CITY OF ALBUQUERQUE

**RE: 1125 Snow Vista Blvd SW
Grading & Drainage Plan
Engineer's Stamp Date: 12/12/2025
Hydrology File: M09D036
Case # HYDR-2025-00447**

Based upon the information provided in your submittal received 12/16/2025, the Grading & Drainage Plan **is not approved** for Demo Permit, Grading Permit, or Building Permit. The following comments need to be addressed for approval of the above referenced project.

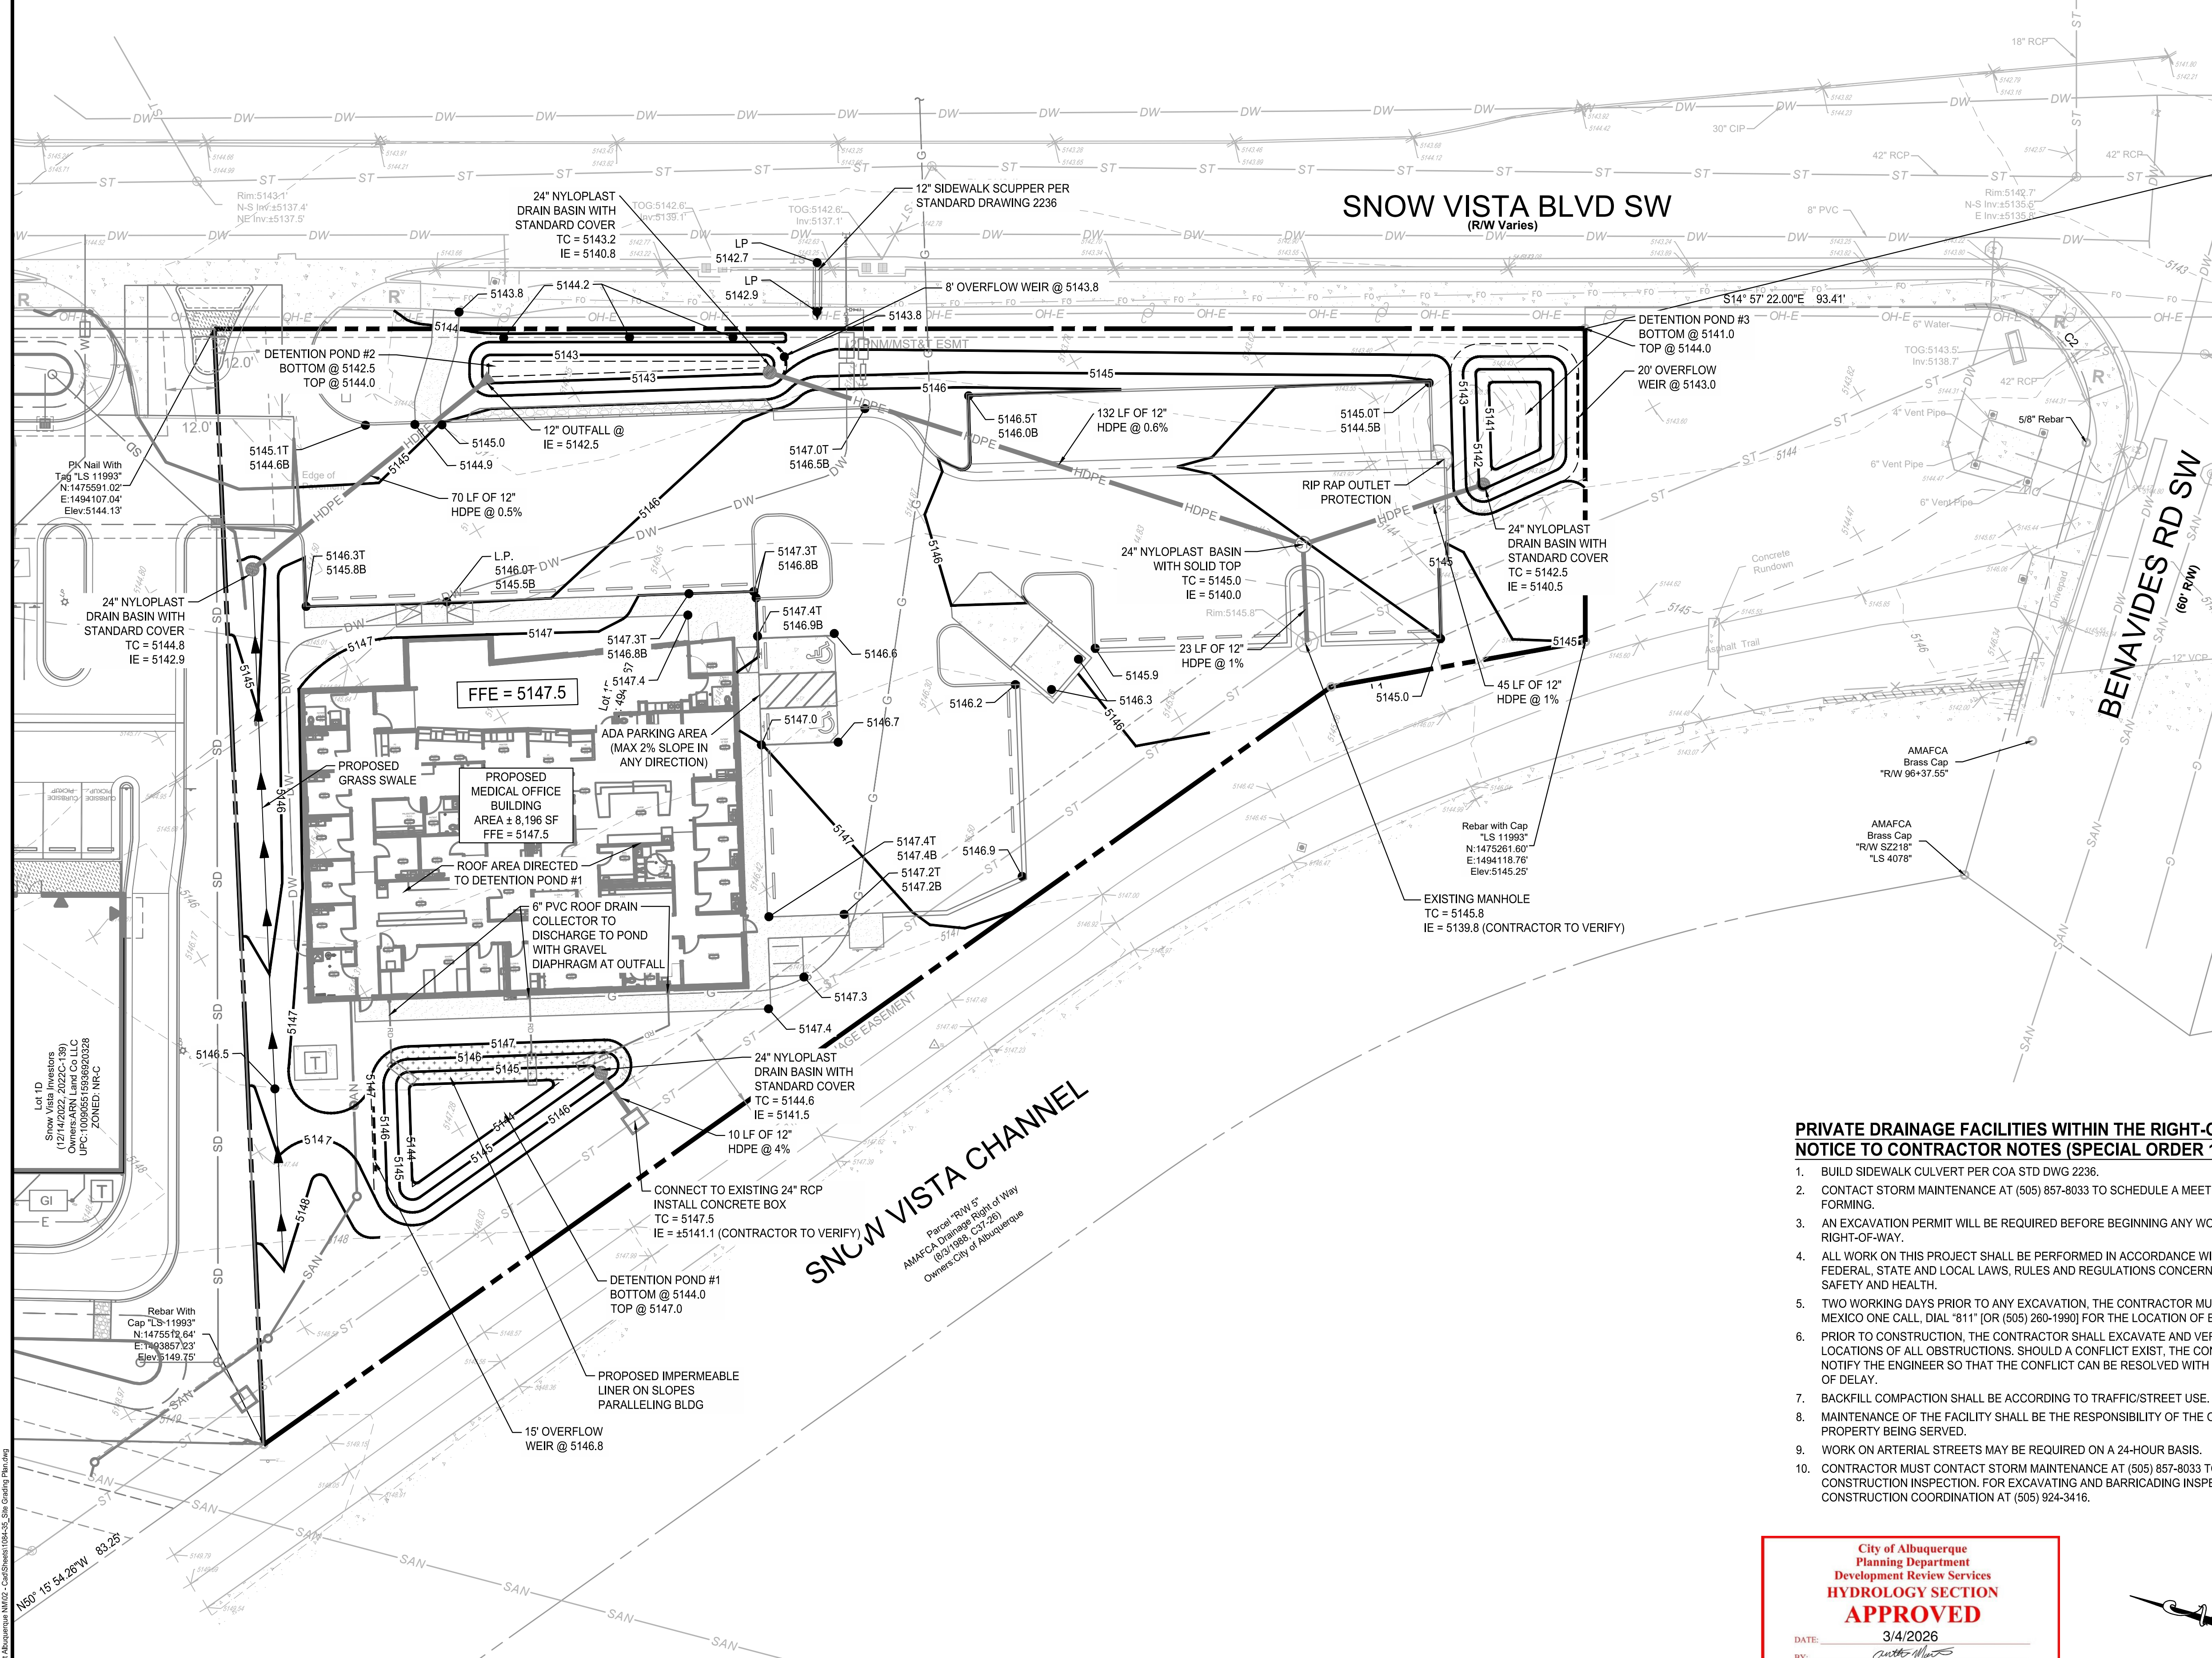
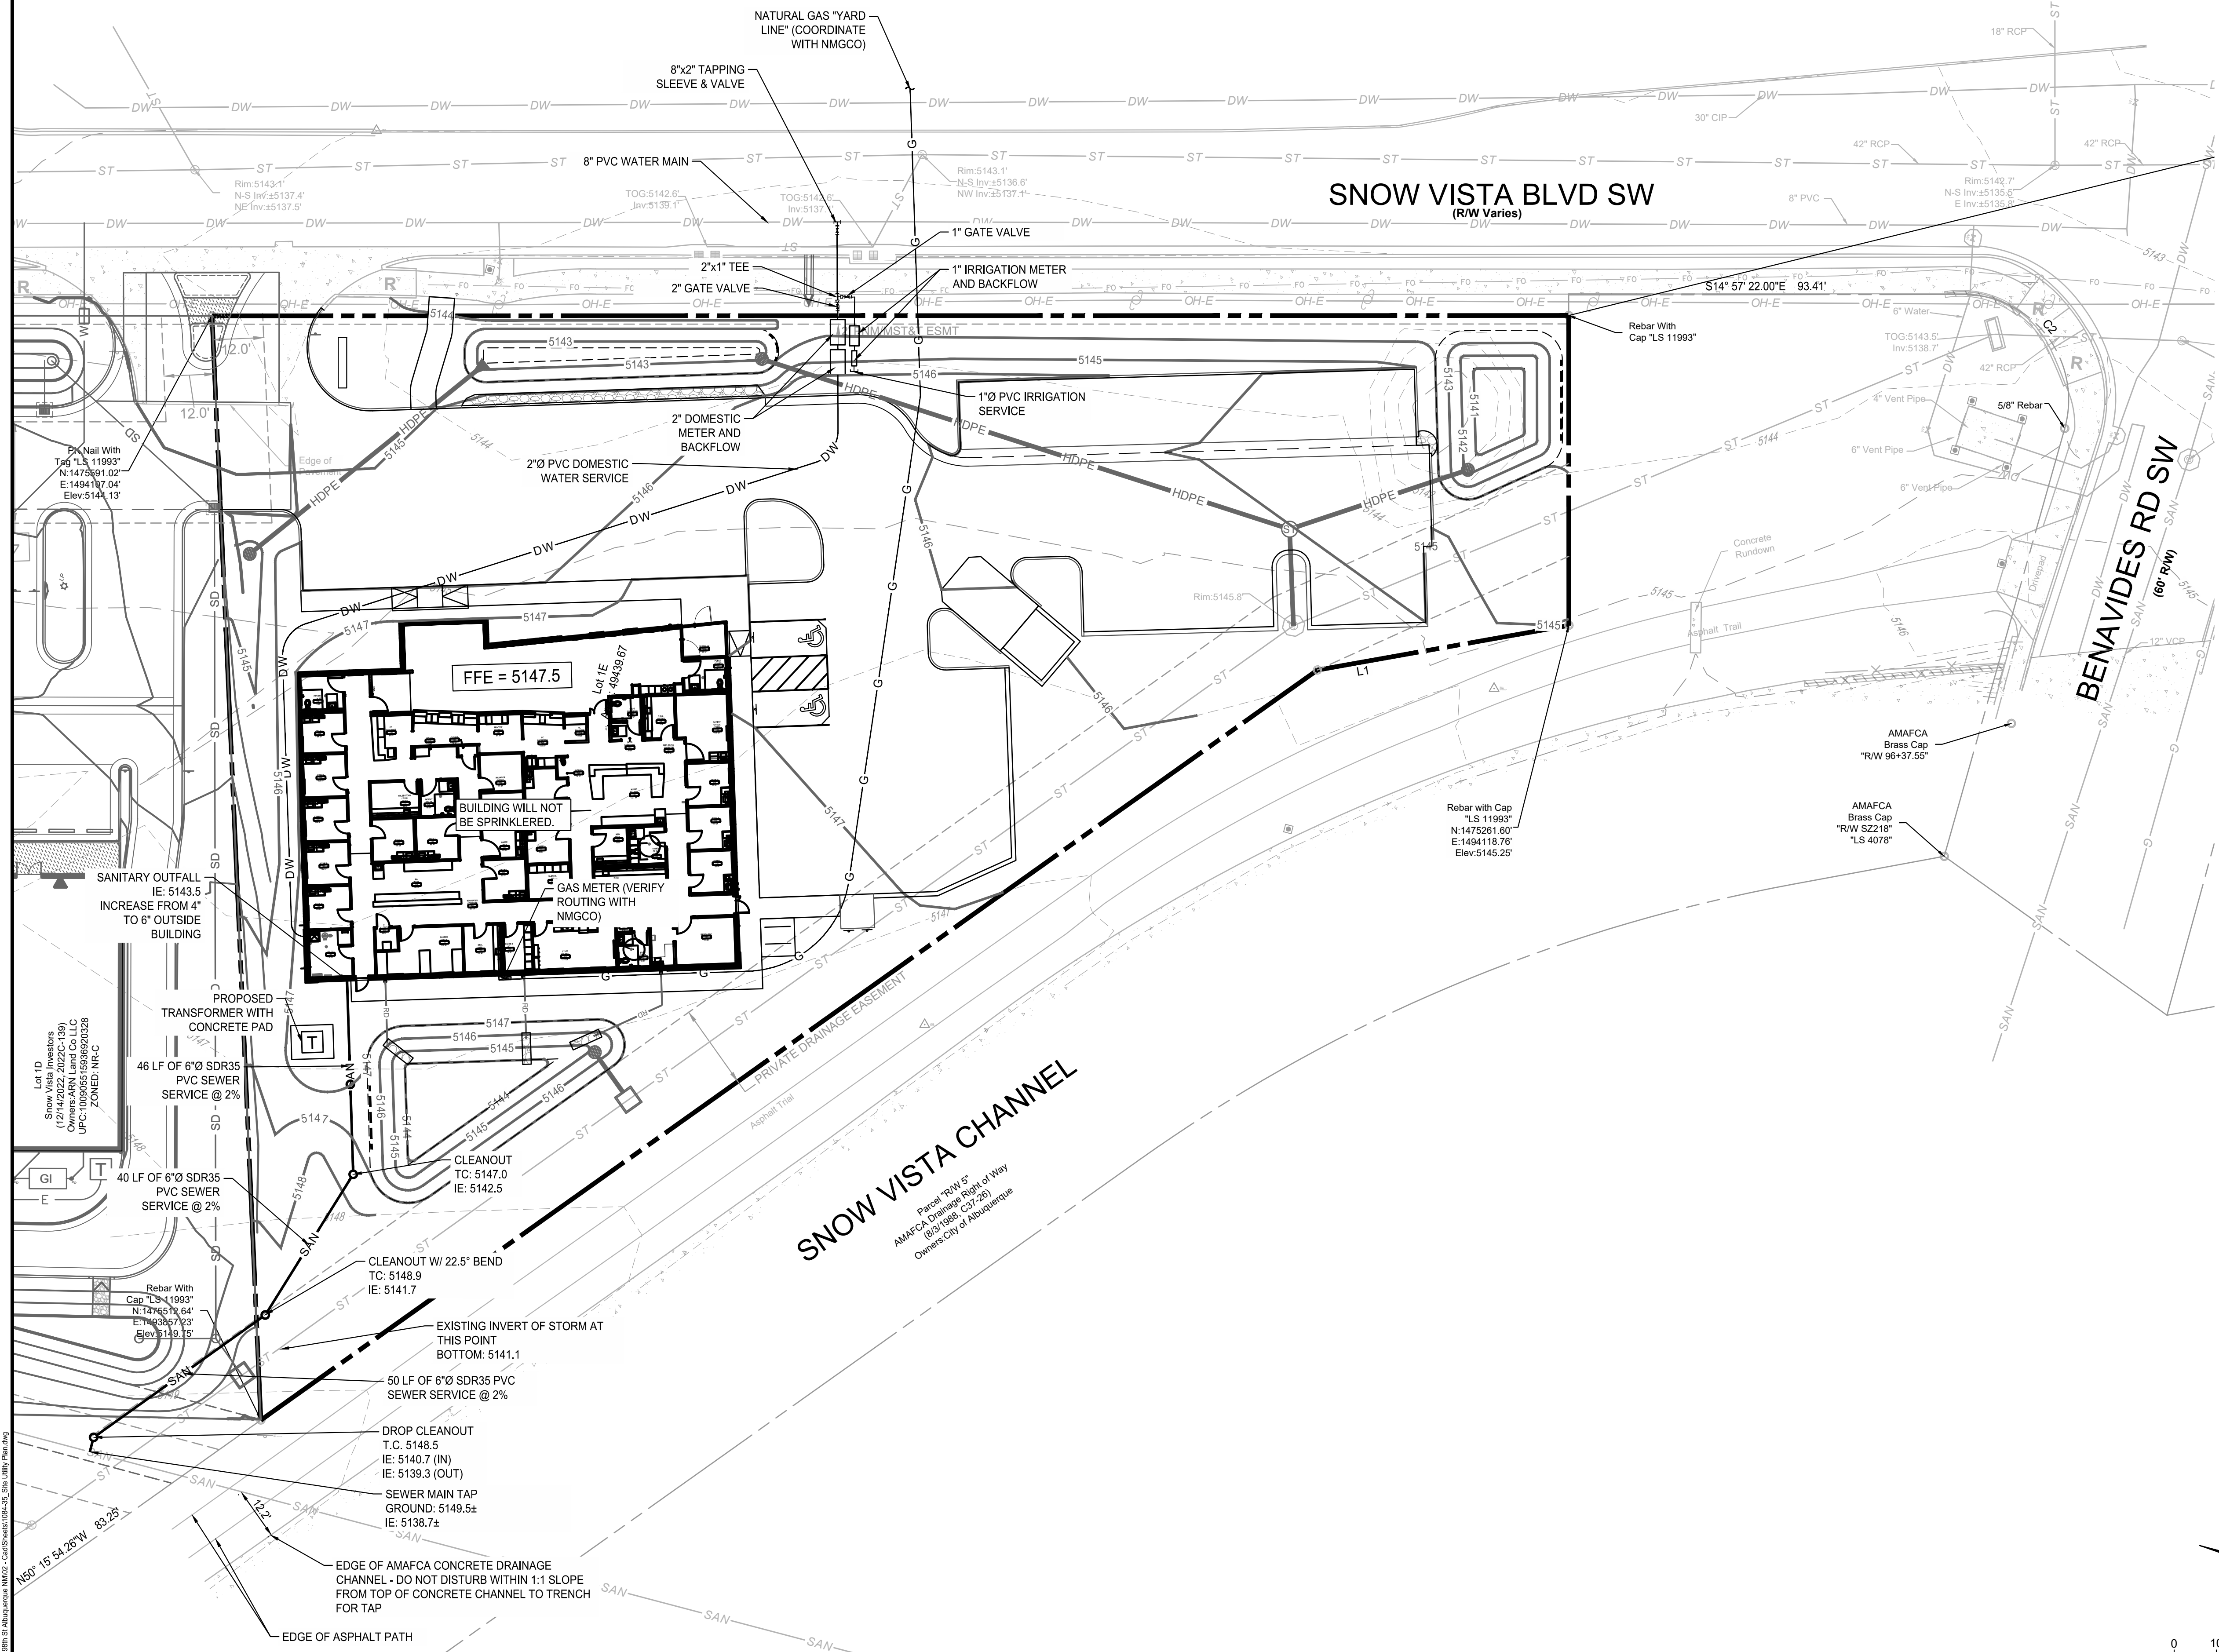
1. Sheet C2.1 – Pre-Developed conditions exceed 100%

- Stormwater discharges across the sidewalk are not allowed on collector roads and above; provide sidewalk culverts or drain lines through the curb.
- Please reference City of Albuquerque standard detail No. 2236 – Sidewalk Culvert with Steel Plate Top at the sidewalk culvert.

- An SO-19 Permit will be required and should be included on the request. Please include the [standard SO-19](#) notes on the grading plan. (This is for the sidewalk culvert)

- Please provide the Benchmark information (location, description and elevation) for the survey contour information provided.
- Please provide the FIRM Map and floodplain note with effective date.

- Please provide the legal description of the property.
- Please number the ponds and include a label on each with the SWQV and elevation, the 100-year volume and elevation, the peak 100 year inflow and outflow, the spillway crest elevation, the spillway flow depth, and the dam top elevation.

- Show the Finished Pad and the Finished Floor elevations of the structure on the plan.
